<b>Application Ref:</b>	3/2025/0481			 <b>Ribble Valley Borough Council</b> <small>www.ribblevalley.gov.uk</small>
<b>Date Inspected:</b>	N/A	<b>Site Notice:</b>	N/A	
<b>Officer:</b>	LW			
<b>DELEGATED ITEM FILE REPORT:</b>				<b>APPROVAL</b>

<b>Development Description:</b>	Certificate of Lawfulness for a proposed single storey rear extension including external flue, and insertion of rooflights.
<b>Site Address/Location:</b>	29 Somerset Avenue, Wilpshire, BB1 9JD.

7193 - P01A

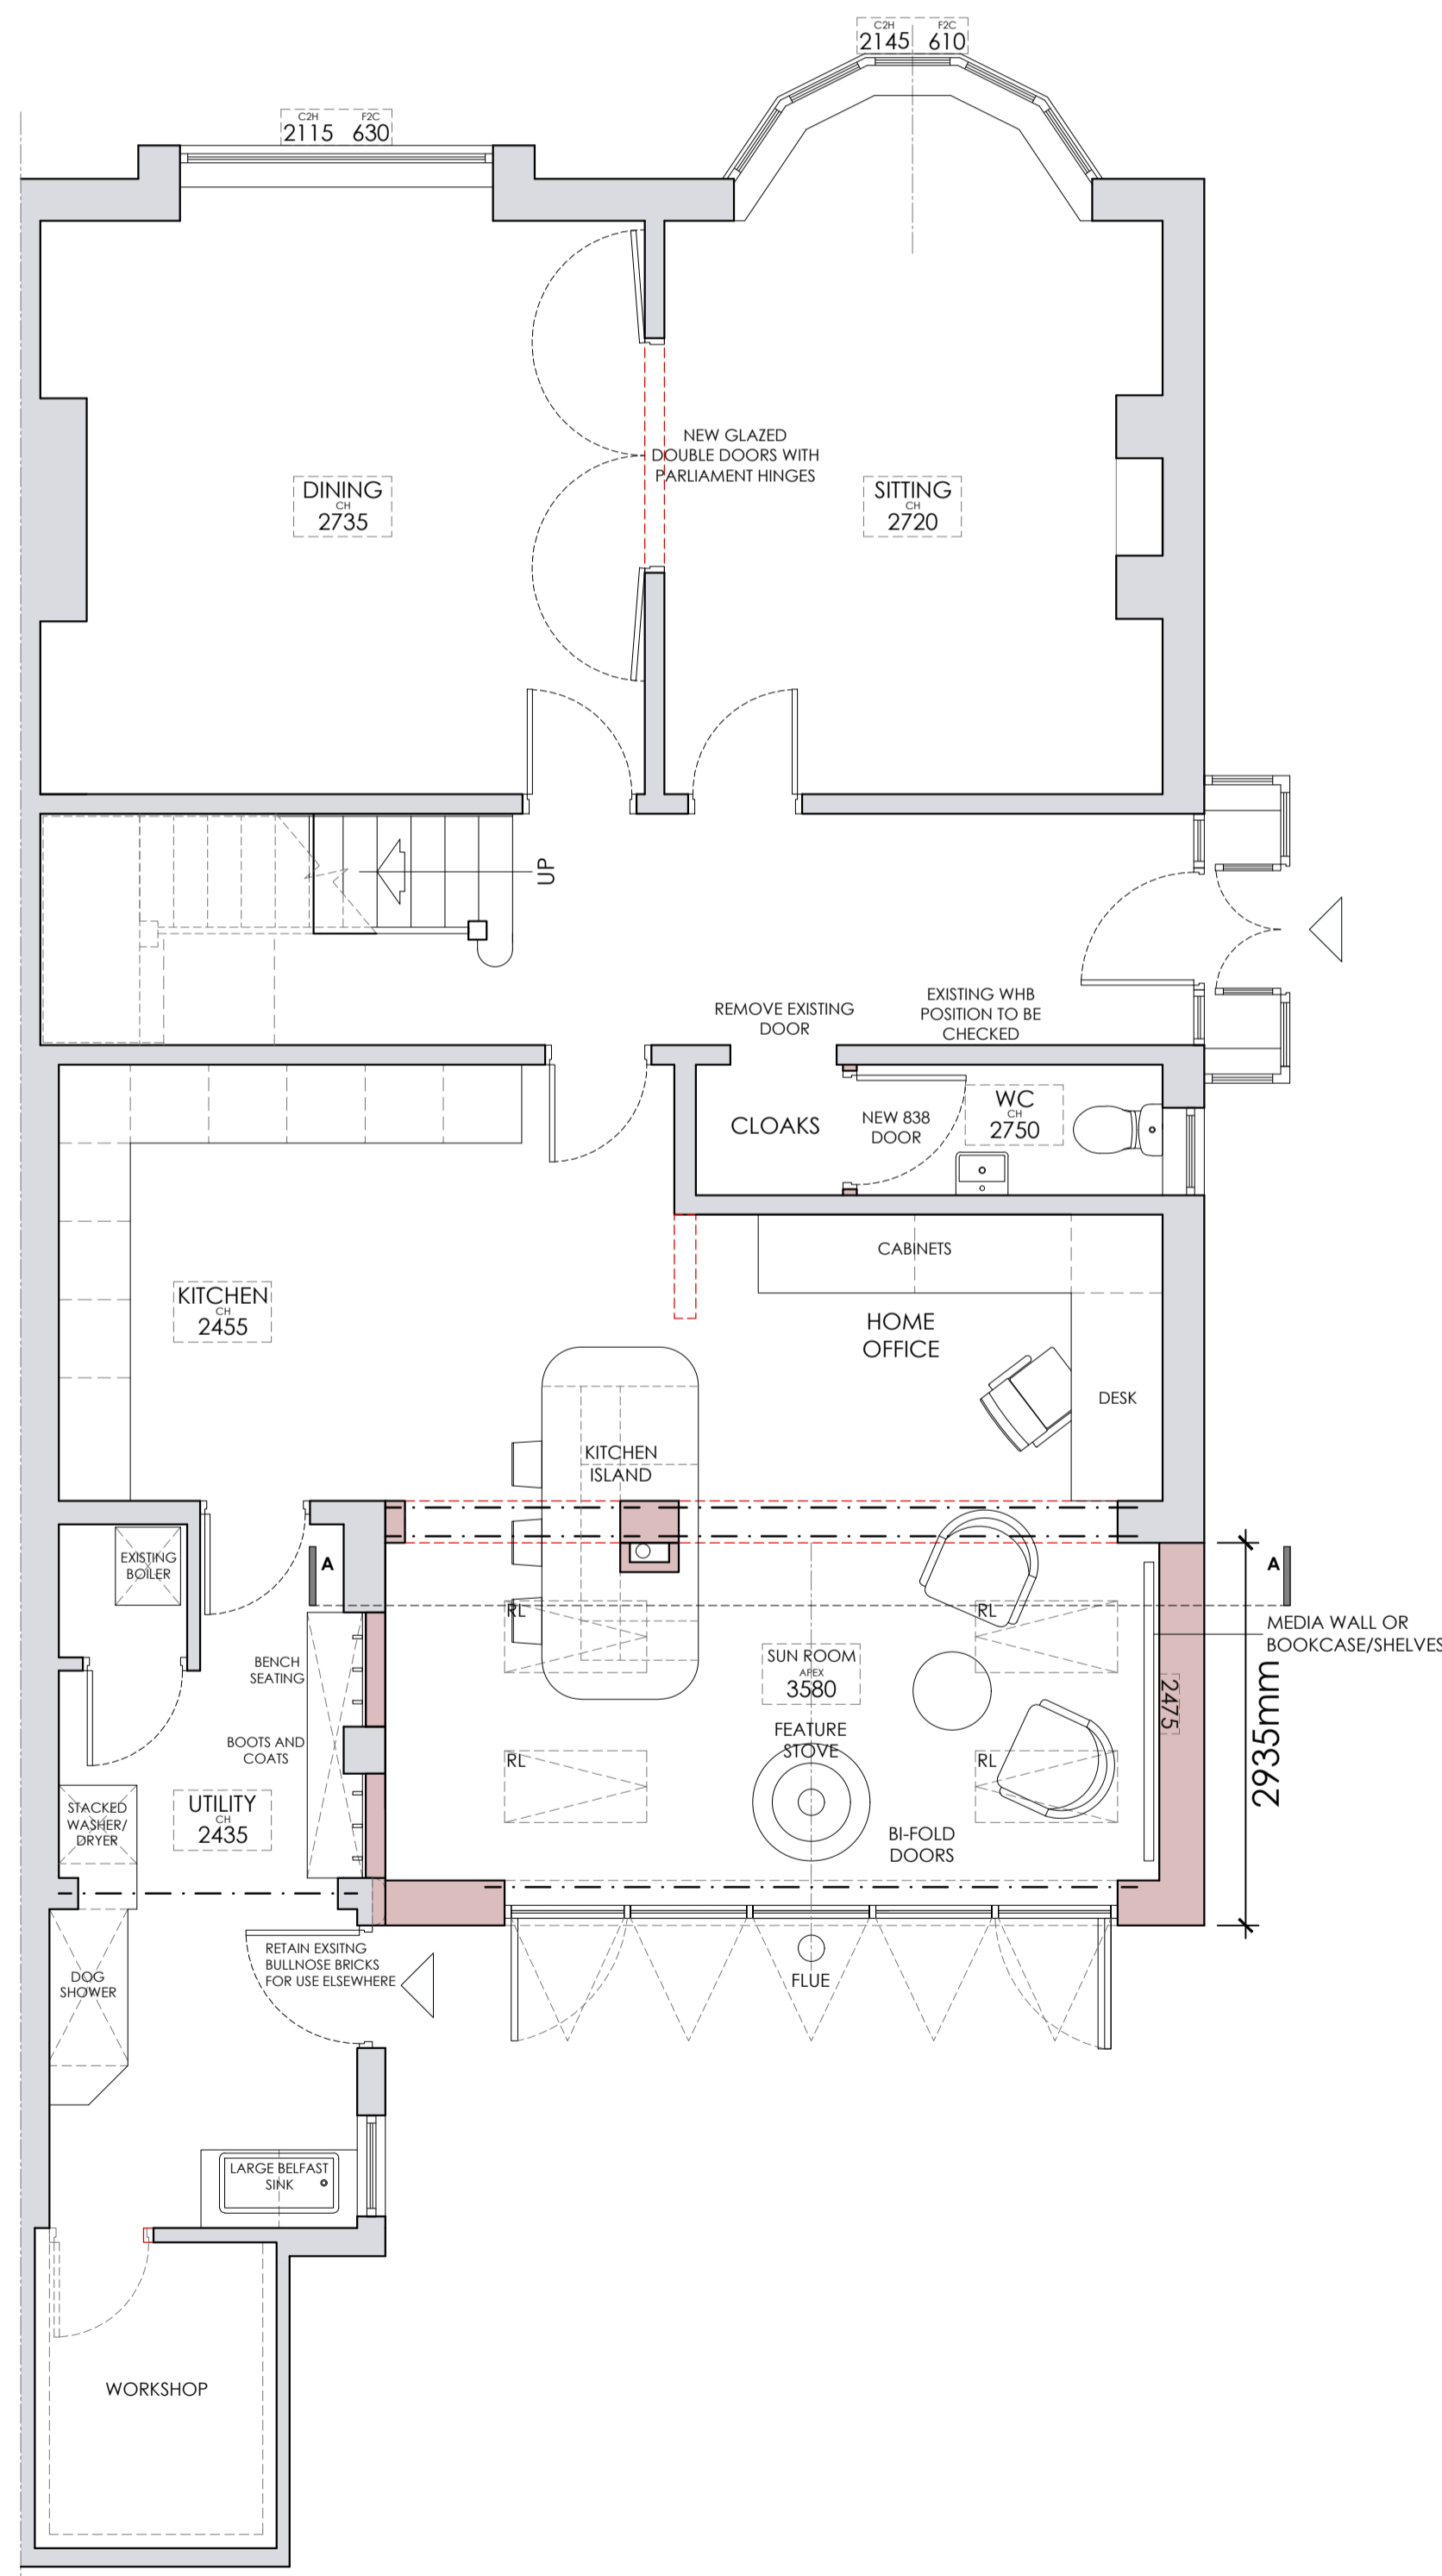
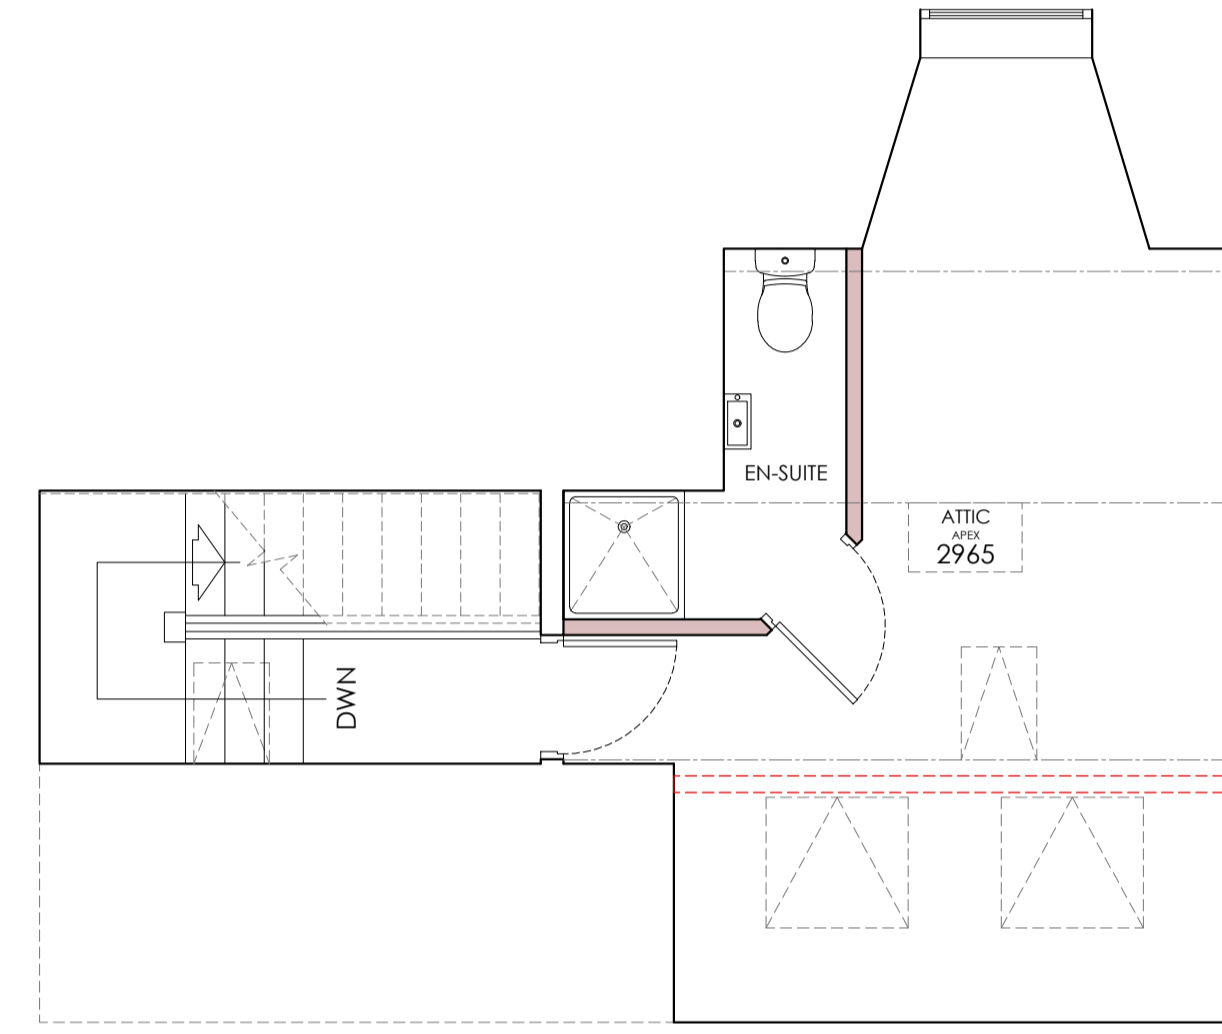
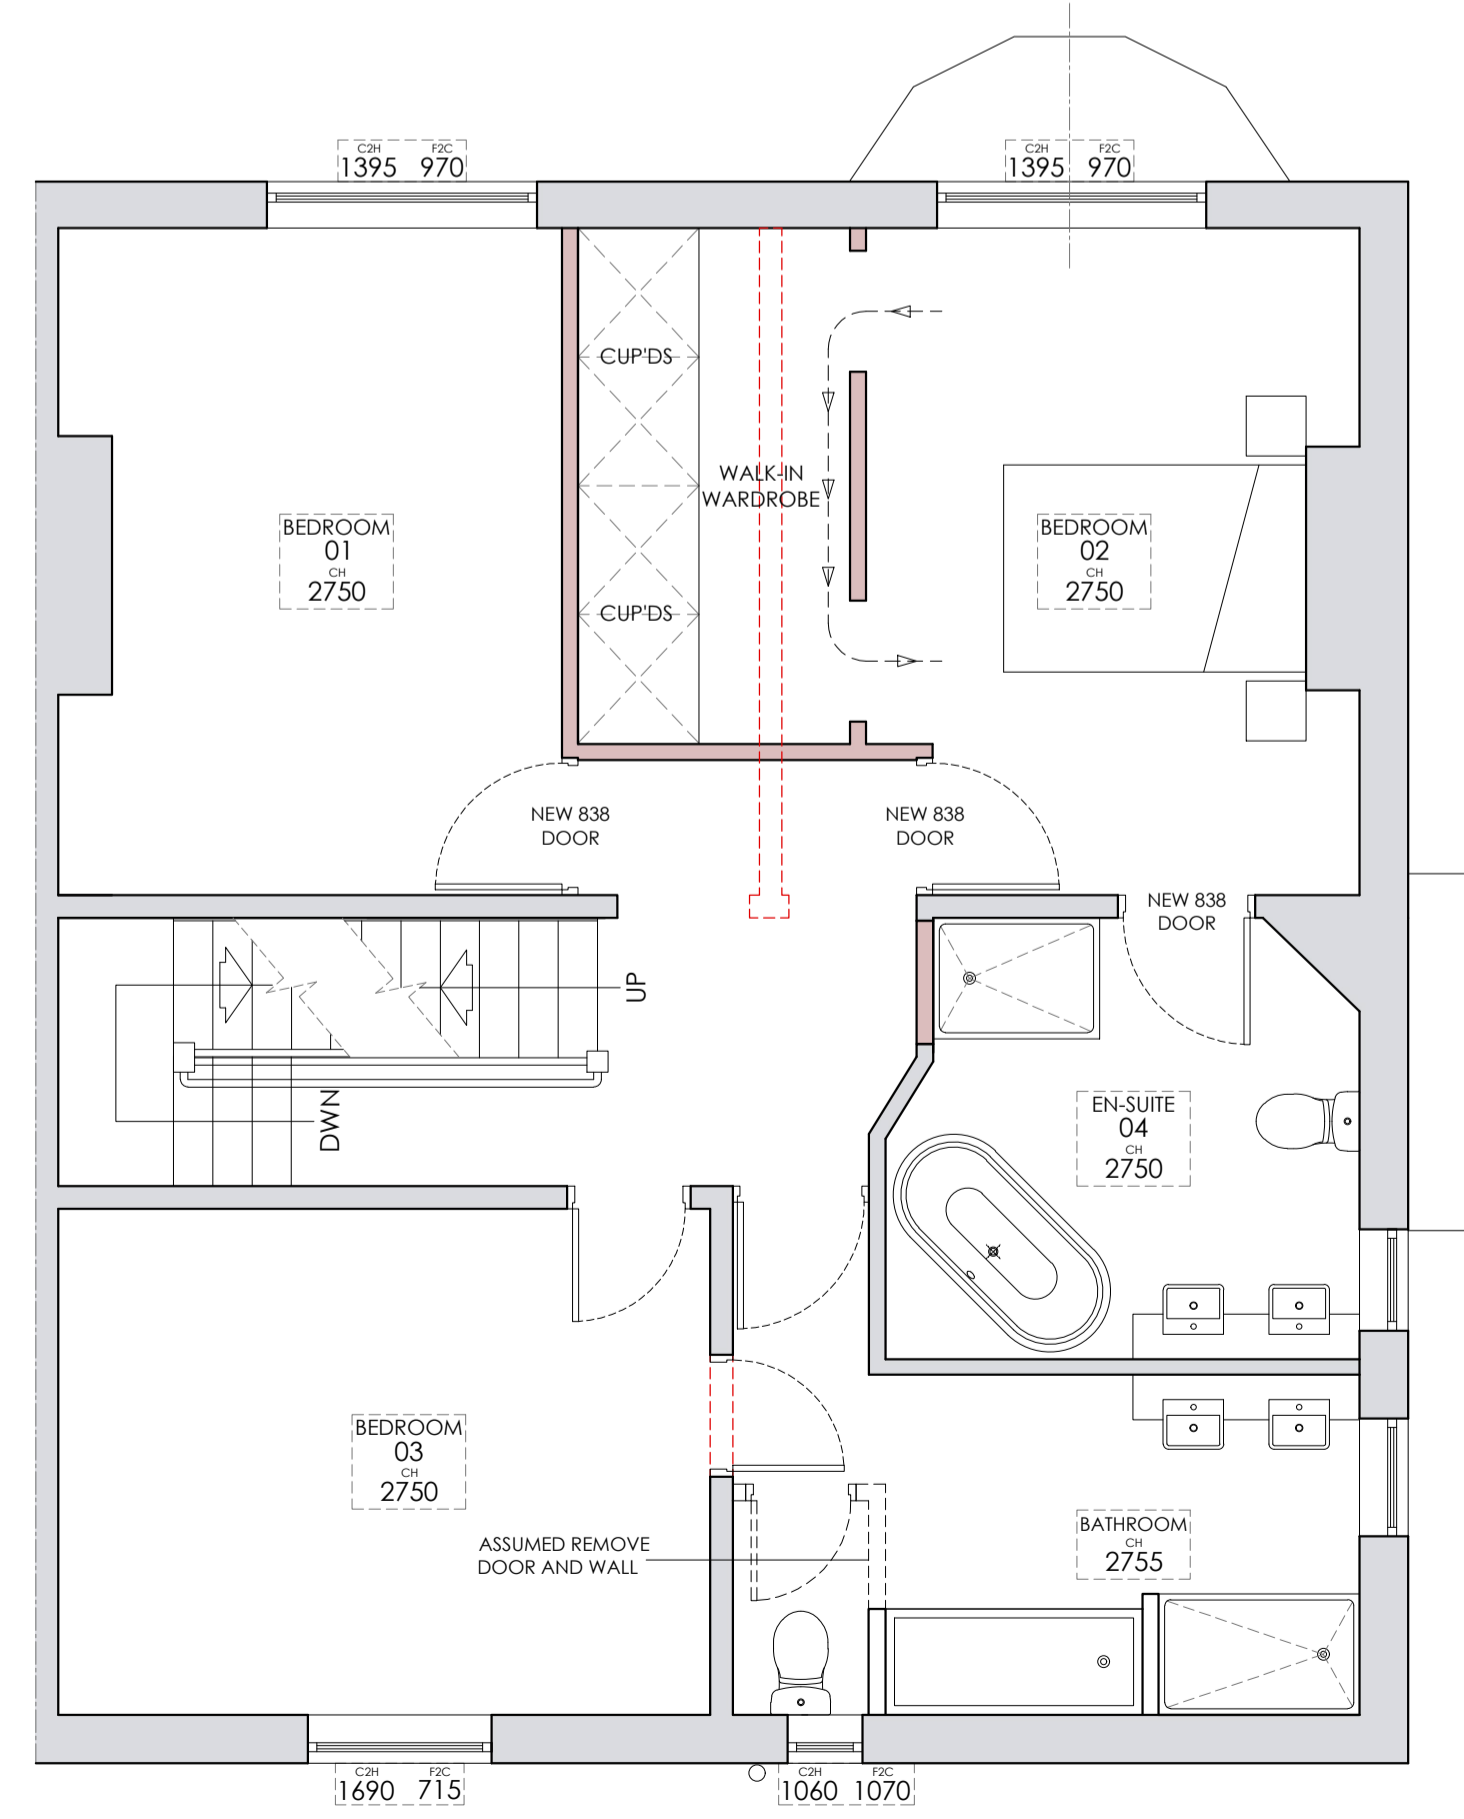
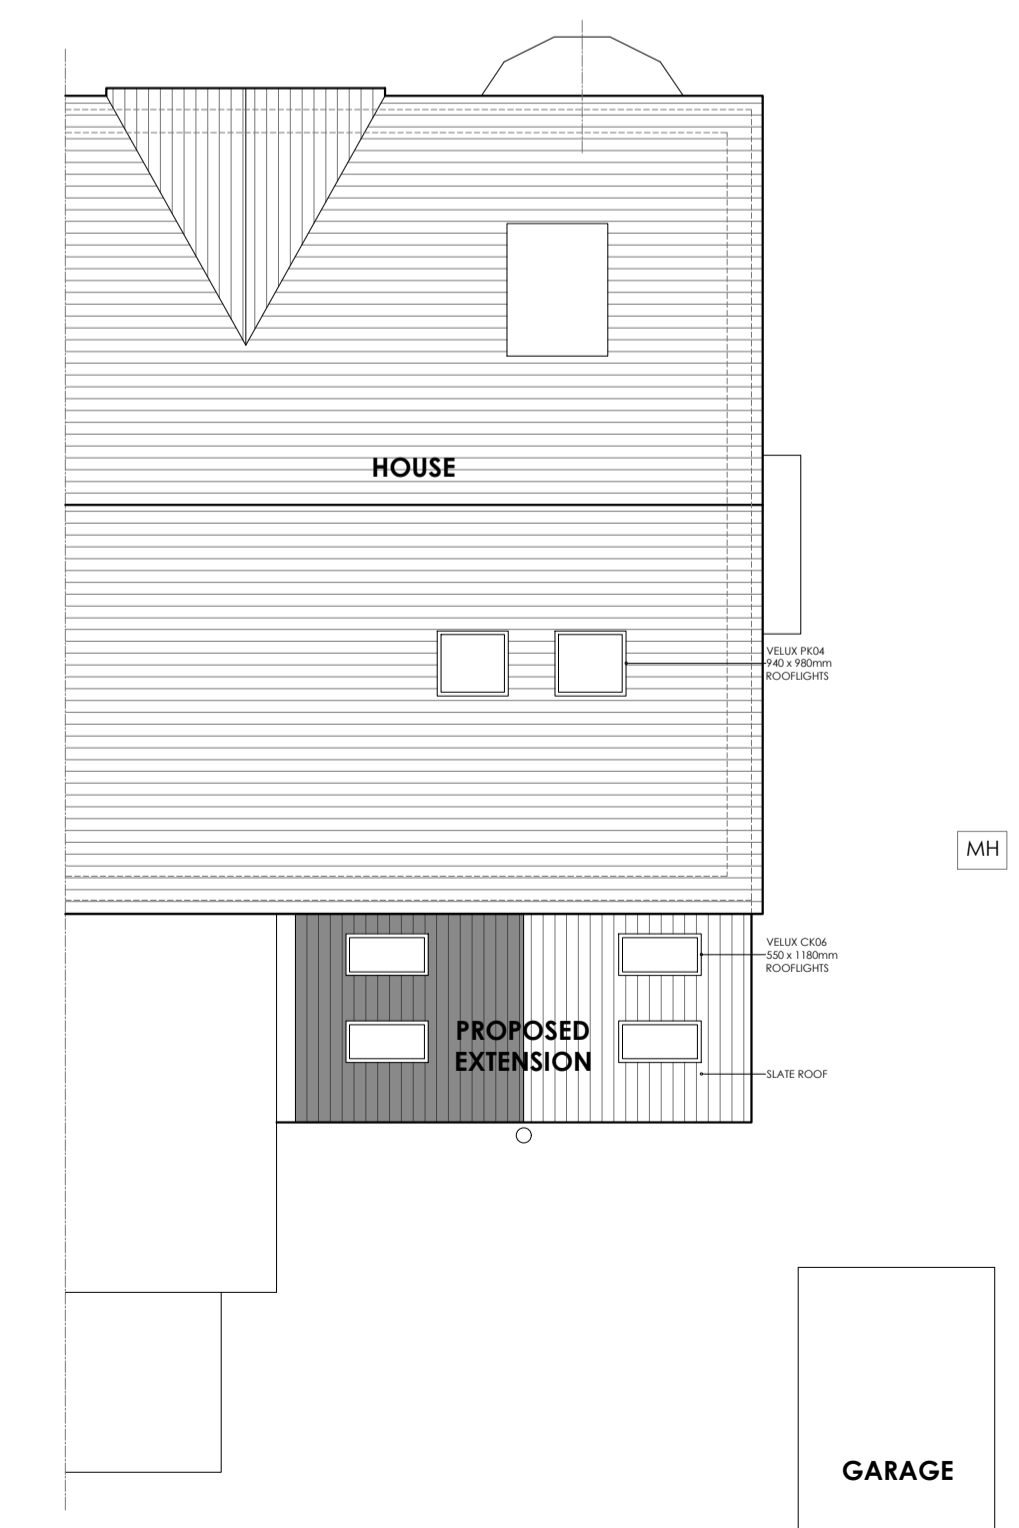
Consent is sought for a Certificate of Lawfulness for the construction of a proposed single storey rear extension projecting 2.9m from the rear elevation of the existing dwellinghouse with an eaves and ridge height of 2.7m and 4m respectively. As part of the extension, an external flue would also be incorporated with a maximum height of 5m measured from ground level.

As part of the proposal, 2no. rooflights would also be incorporated to the rear roof slope of the main dwellinghouse.

**The proposed extension would not extend more than 3m from the rear wall of the dwellinghouse and would not exceed 4m in height. It is noted that the proposal would include an external flue with a maximum height of 5m – however, this forms a separate assessment under Class G.**

**The proposed extension would be finished in brickwork and slate roof tiles to match the existing dwellinghouse.**

**The proposed flue would not exceed the highest part of the roof by more than 1m.**

The proposed development constitutes permitted development under Schedule 2 Part 1 Class A, Class C and Class G of the Town and Country Planning (General Permitted Development) (England) Order 2015 (as amended), subject to the conditions outlined in A.3 and C.2 of this Part.

That the Certificate of Lawfulness be granted.
